Planning Reference: M/91/11

We understand you are the case officer for planning application M/91/11/. Please find below our objections to the proposed plans for developing a first floor extension to form two bedrooms on the north of 2 West Close.

Proposed Side Elevation

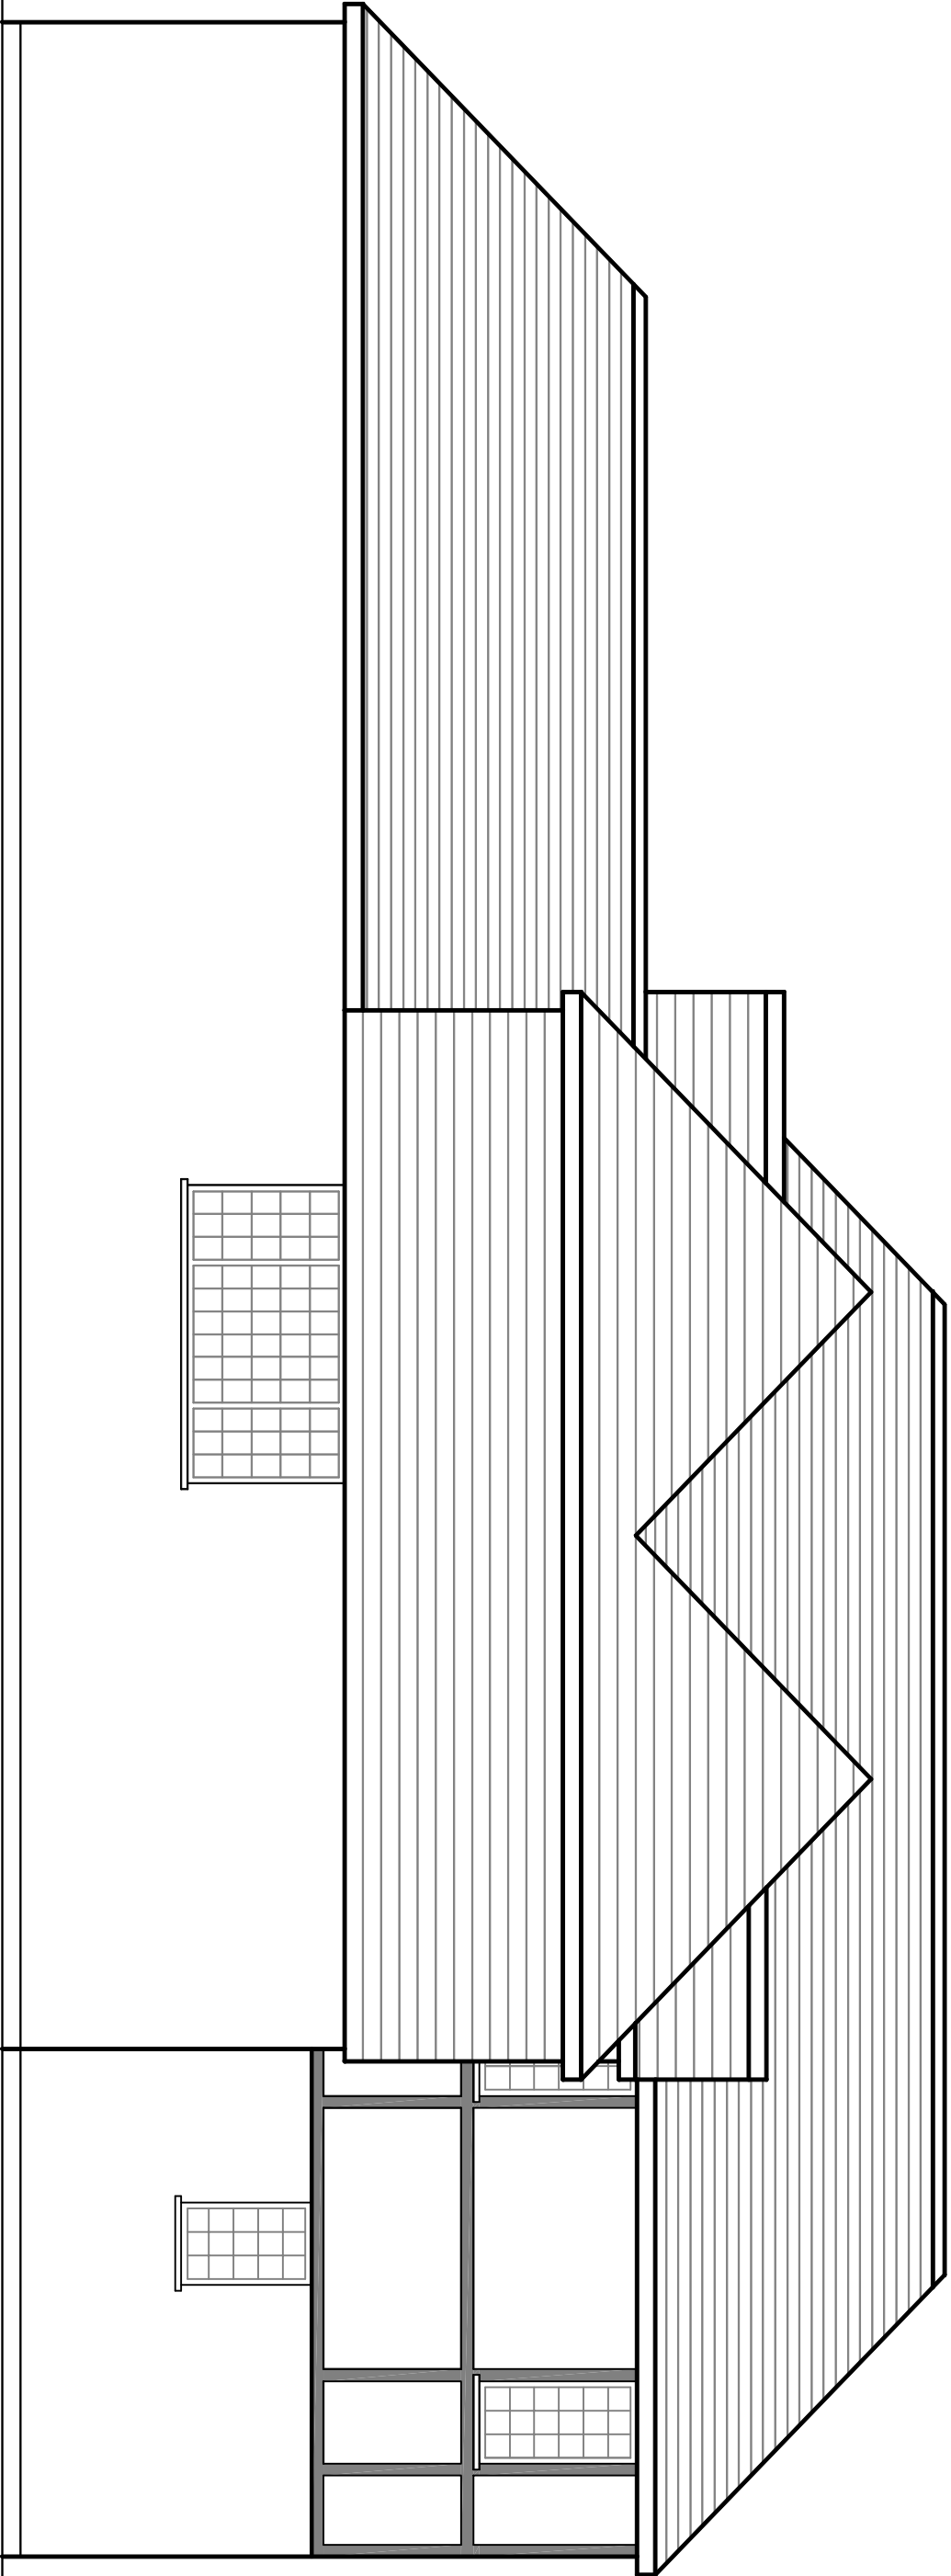
The drawings presented do not appear to work technically. Roof heights on the plans do not look high enough to create habitable rooms on the first floor. The proportions of bedroom 6 (proposed floor plan) do not correlate with the proposed side elevation plan and it allows no possibility of passage under the proposed gully roof from bedroom 6 to the proposed en suite bathroom. Head heights do not reconcile and the proposed front elevation drawing indicates roof height will be much greater than that shown on the proposed side elevation. This raises concerns that the side roof construction is likely to be much higher thus exacerbating the aforementioned objections of loss of light and amenities of neighbouring residential property.

2 West Close			Mr & Mrs Thomas		
			09	Edition 0	Sheet

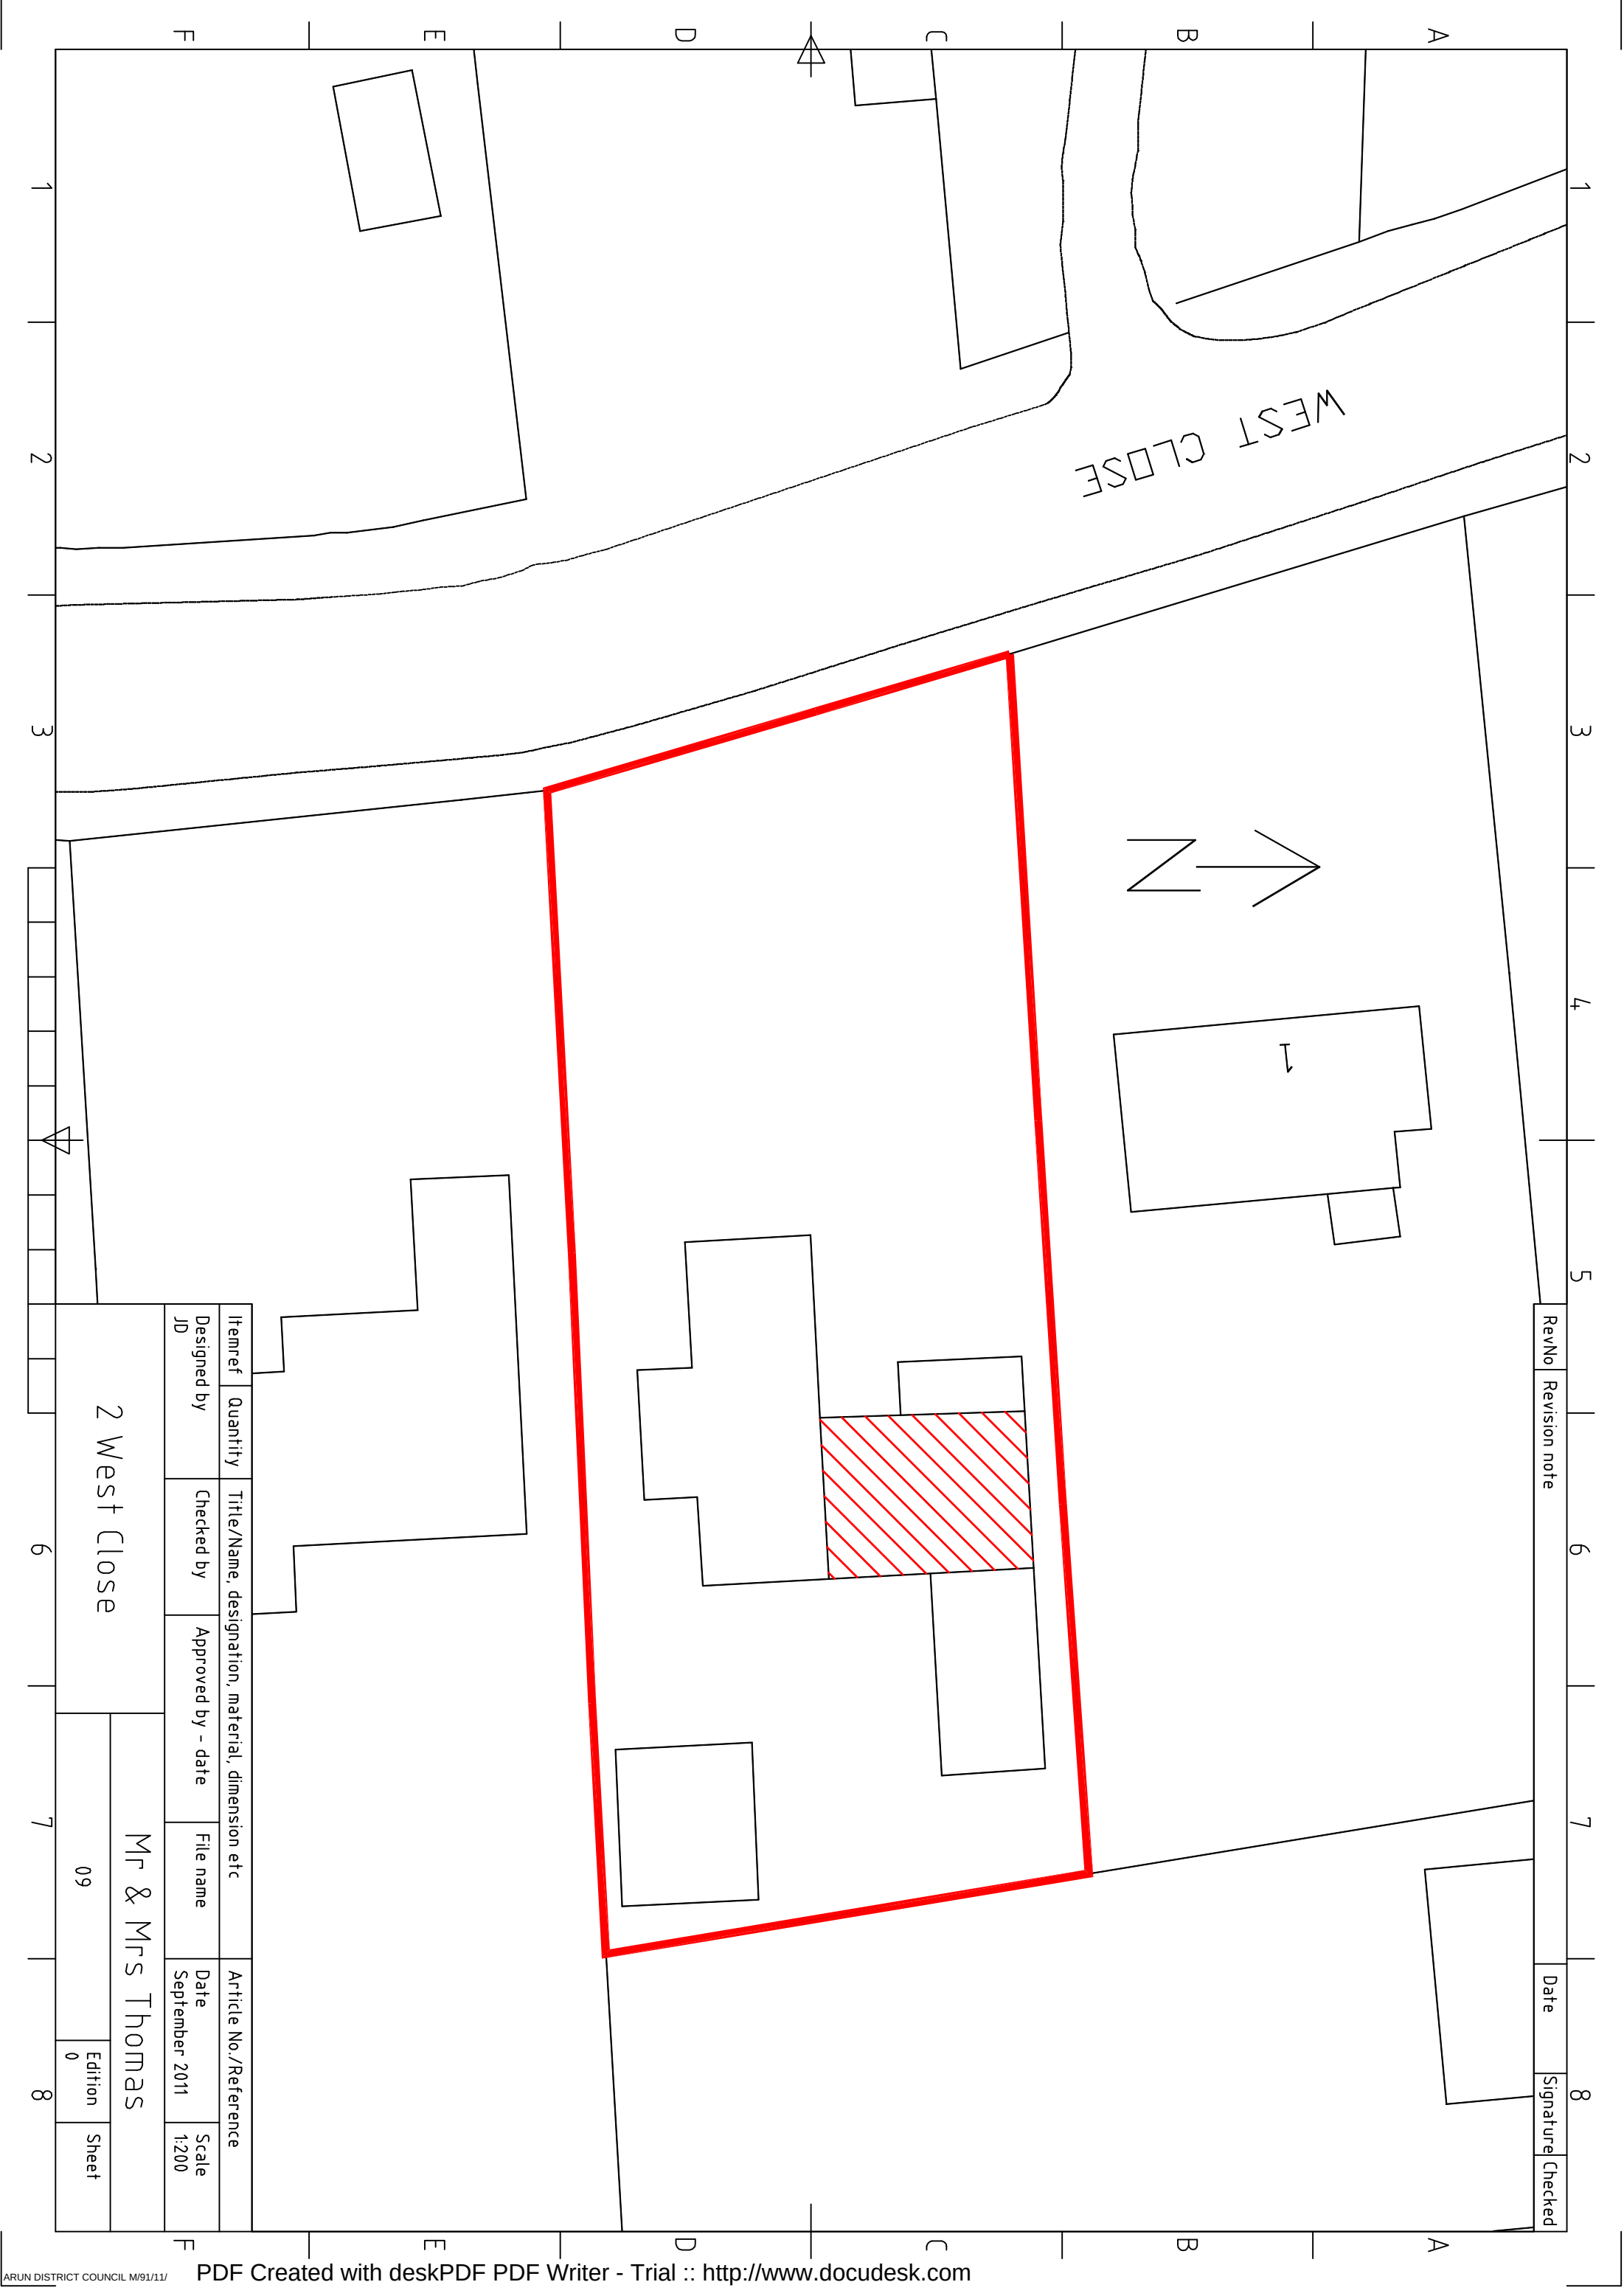
The application shows inaccurate block plans (08 and 09) from over 5 years ago, prior to the extension to 1 West Close (planning application M/76/06). This is misleading as the plans do not accurately represent how the proposed extension will impact on both the ground and first floors of 1 West Close. We recommend a site visit to assess the impact on the neighbouring property to the north. Please refer to the enclosed overhead photo of our plot taken in 2010 on which we have indicated the layout of our property and corner garden seating area, (the corner mosaic seat has been progressed since the photo was taken).

The current single storey extension is already very close to the boundary of 1 West Close to the North where fencing, hedging and leylandii trees are located (see photo enclosed). The distances are not accurately represented in the block plans on the application and a site visit is required to assess the impact.
